# Rezoning Transportation Analysis

Petition Number: #2022-123

## Revision Log:

Date	Description
12-28-22	First Review (TM)
01-24-23	Second Review (DR)
02-23-23	Third Review (DR)

REZONING PLAN
RZ.01

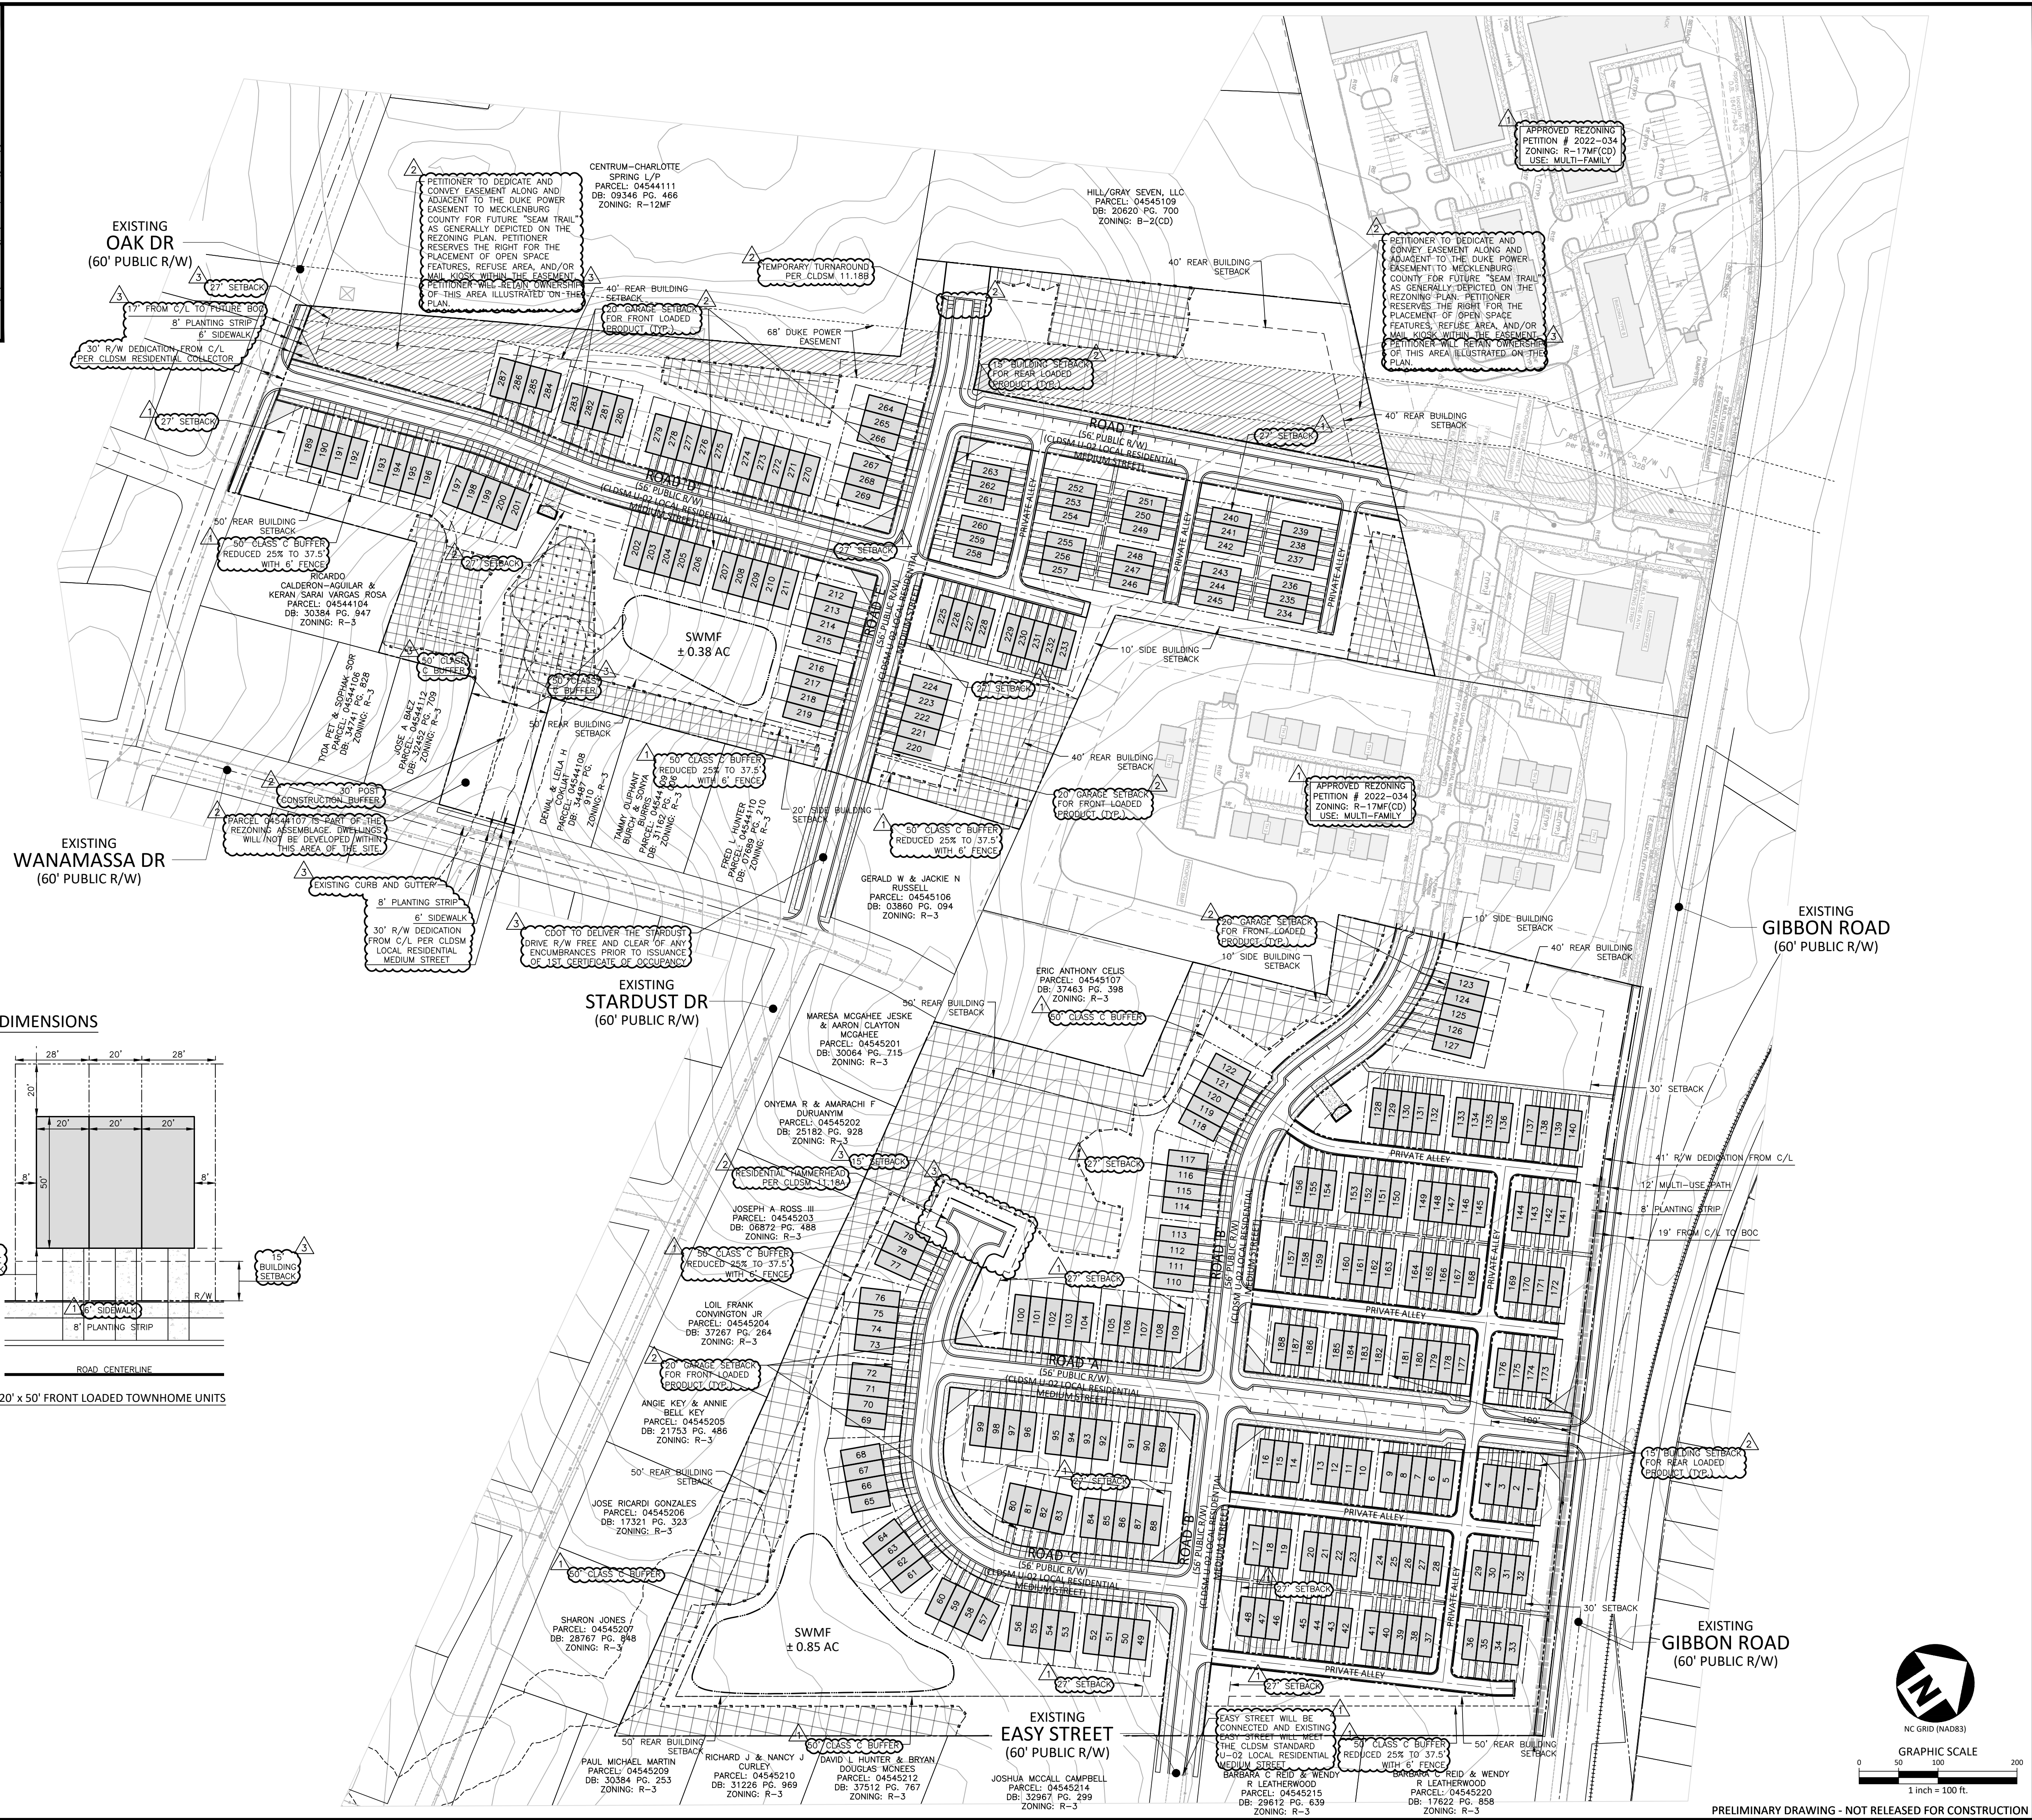
- a. ~~Gibbon Road:~~ Location of curb and gutter to be moved to 19 feet from roadway centerline to accommodate the Charlotte Streets Map with a roadway typical section of GLDSM 11.09 Minor Thoroughfare.
- b. ~~New Comment from 2-23-23: Oak Drive:~~ Curb and gutter shall be placed along the entire site's frontage. Label and dimension the proposed curb line from the exiting centerline of the road.
- c. ~~New Comment from 2-23-23: Wanamassa Drive:~~ Curb and gutter shall be placed along the entire site's frontage. Label and dimension the proposed curb line from the exiting centerline of the road.

Label and dimension the curb and gutter from the centerline for each road on the site plan.

**Outstanding Comment from 1-24-23:** With public streets D, E, and F added. Revise conditional note to commit to construct 8-foot planting strip and 6-foot sidewalk on all internal public roadways.

- New comment from 03-30-2023:** Revise site plan and conditional note(s) by removing callout from site plan and conditional note 3.k.

- New comment from 02-23-2023:** Revise conditional note(s) to commit to dedicate 28 feet of right-of-way from the road centerline along Wanamassa Drive in coordination per CLDSM Local Residential Medium Street and 30 feet of right-of-way from the road centerline along Oak Drive in coordination per CLDSM Residential Collector. The site plan shall label and dimension the right-of-way from the road centerline.

- New comment from 02-23-2023:** Revise site plan and conditional note(s) to commit to construct an 8-foot planting strip and 6-foot sidewalk along the site frontages on Oak Drive and Wanamassa Drive. The site plan shall label and dimension both items from the back of curb and gutter and road centerline.

- New Comment from 1-24-23:** Ensure that public road F connects to the public road A from rezoning petition 2022-034. Clearly show the connection. It is unclear from the site plan if the connection is being made.

Revise site plan and conditional note(s) to label each public roadway per CLDSM U-02 roadway typical section standards.
10. ~~**Rescinded 1/24/2023:** Revise site plan and conditional note(s) to commit to providing a turn around on public roadway C meeting CLDSM standards.~~

11. Revise site plan to provide a minimum internal stem length of 50' between radius returns along Road 'A', between Gibbon Road and the proposed internal alley.
